DRB Application No.: <b>05DRB-00608 (SBP)</b>	Project # <b>1004090</b>
Project Name: <b>North Albuquerque Acres, Unit 3</b>	
Agent: <b>JLS Architects</b>	Phone No.: <b>246-0870</b>

**DEVELOPMENT REVIEW BOARD--SPEED MEMO**

**DRB CASE NO/PROJECT NO: 1004090**

**Re: North Albuquerque Acres, Unit 3/SPBP**

1 Site Plan
C1 1" = 20'-0"

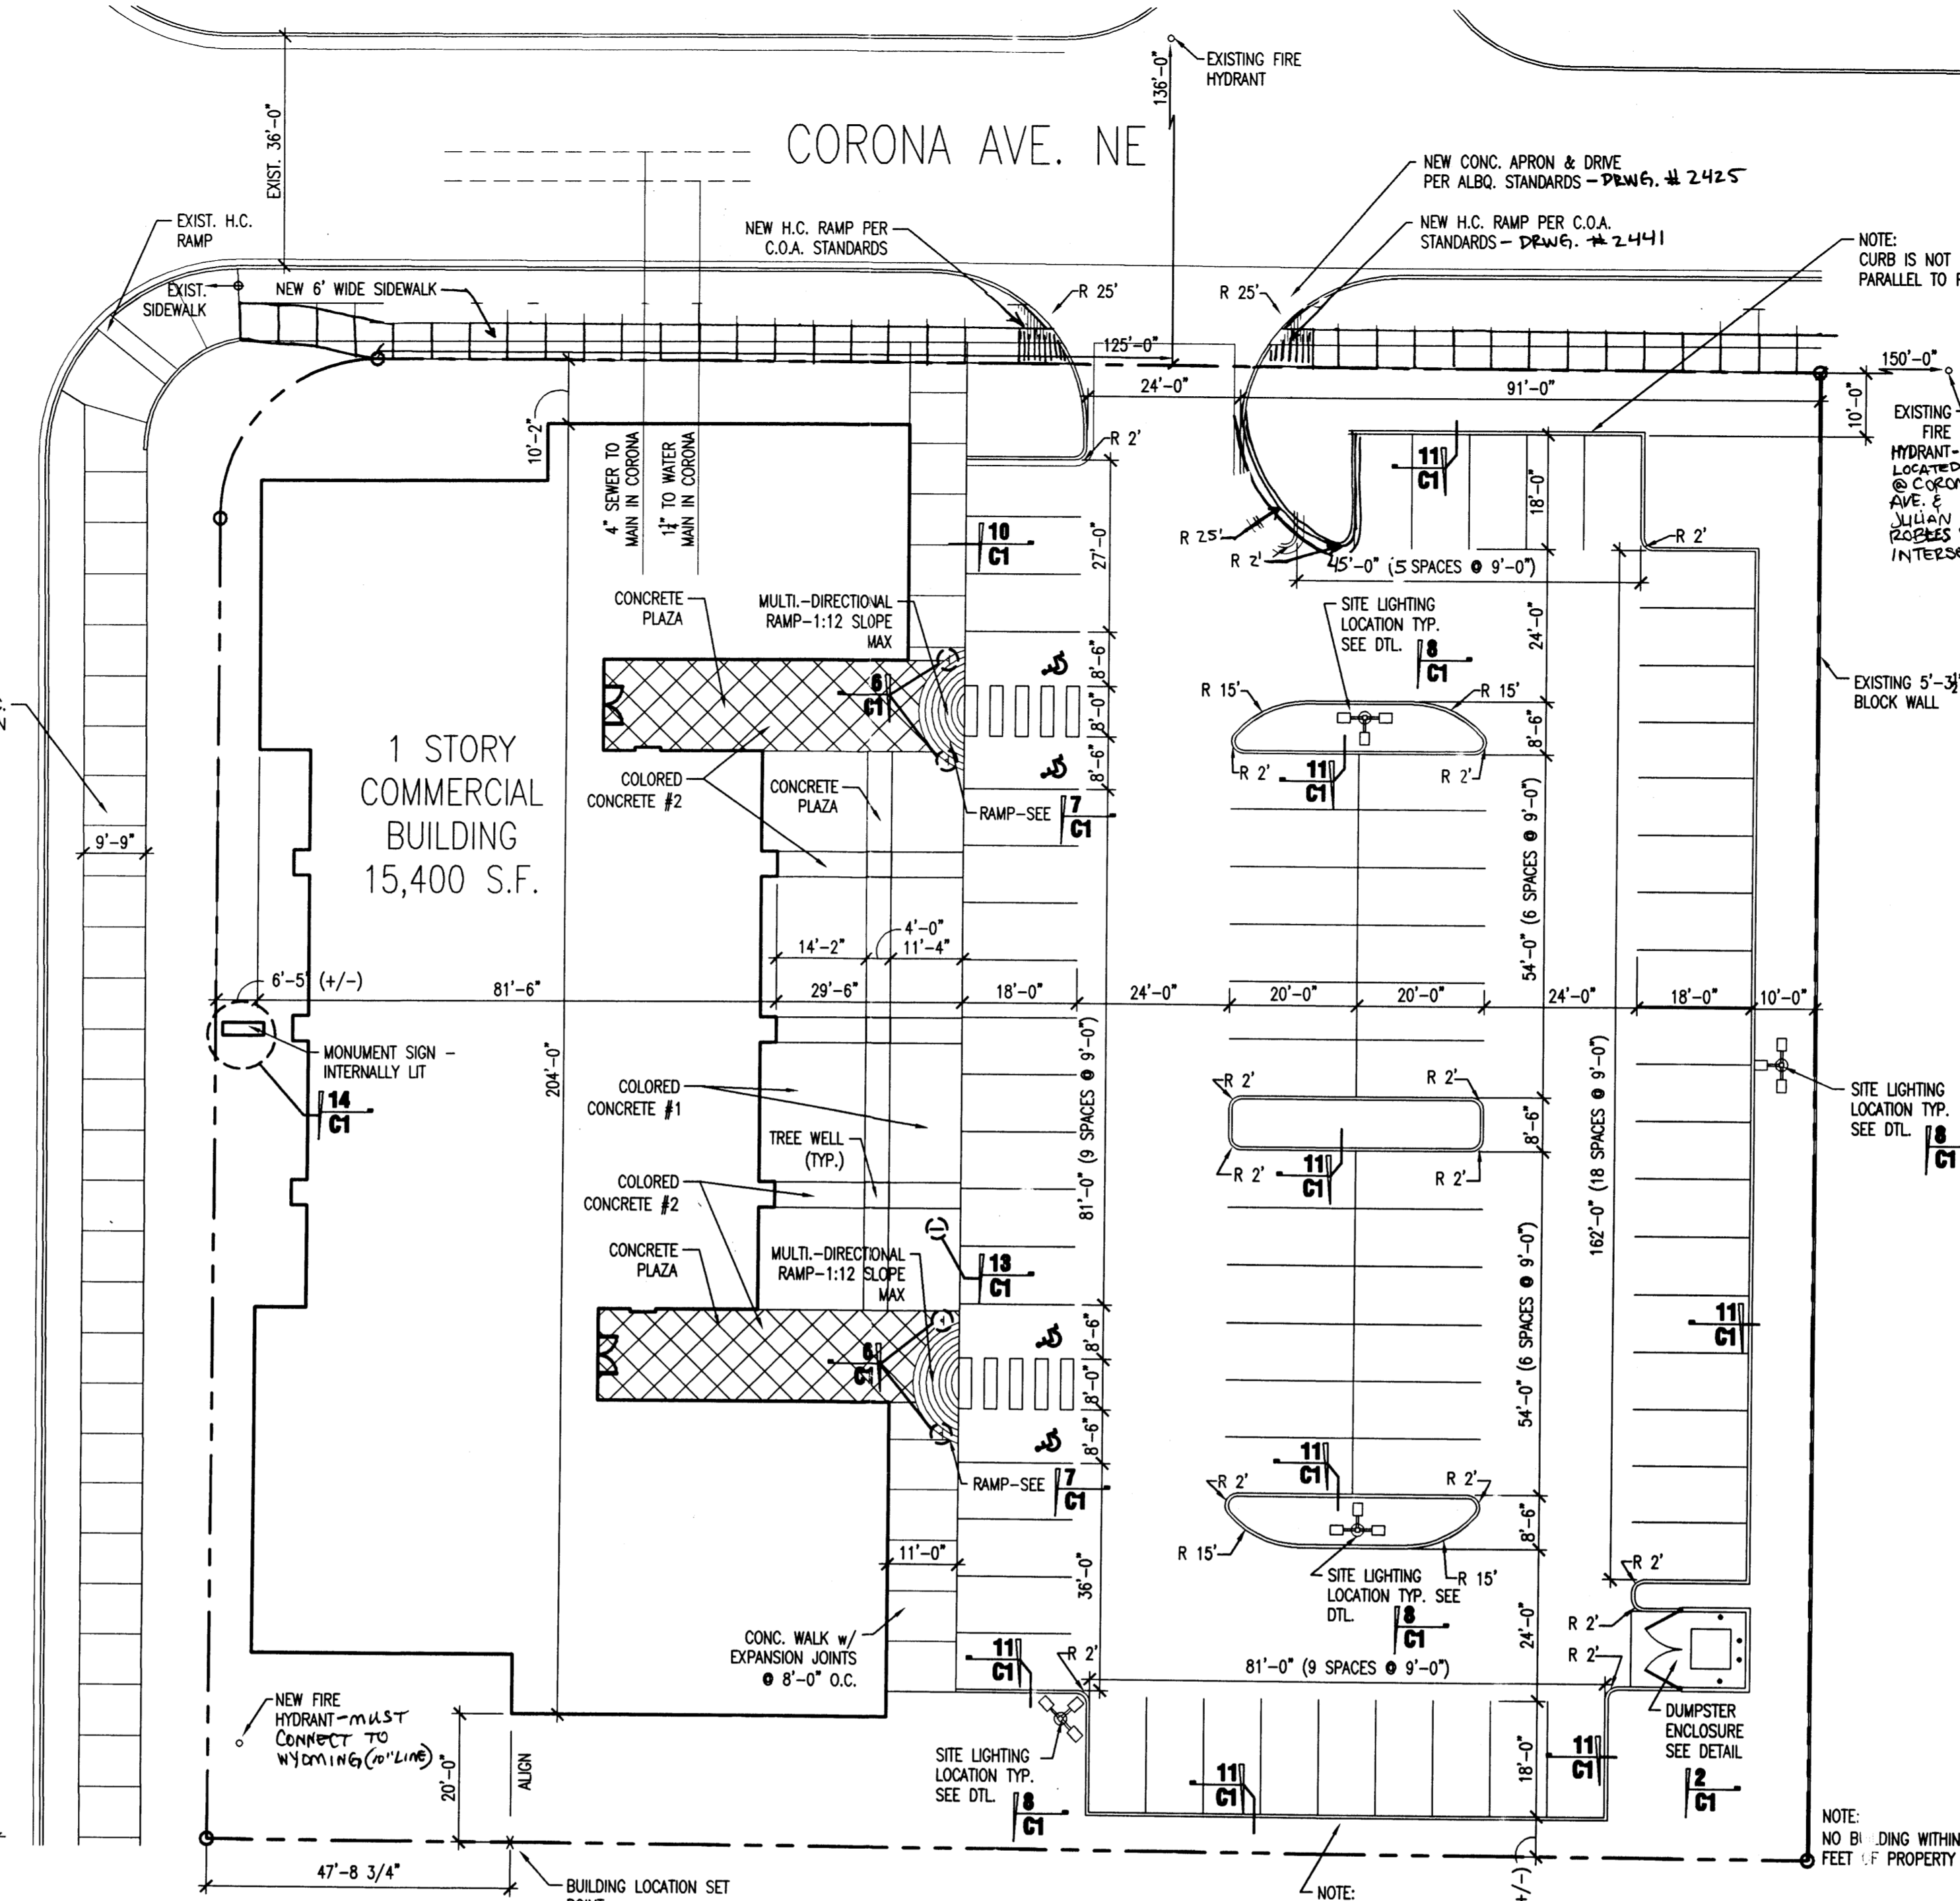
- TRANSPORTATION: - CITY STANDARD DWG 14'S
- RADII
- SW @ PROPERTY LINE ?
- UTILITIES: \_\_\_\_\_
- \_\_\_\_\_
- \_\_\_\_\_
- CITY ENGINEER / AMAFCA: \_\_\_\_\_
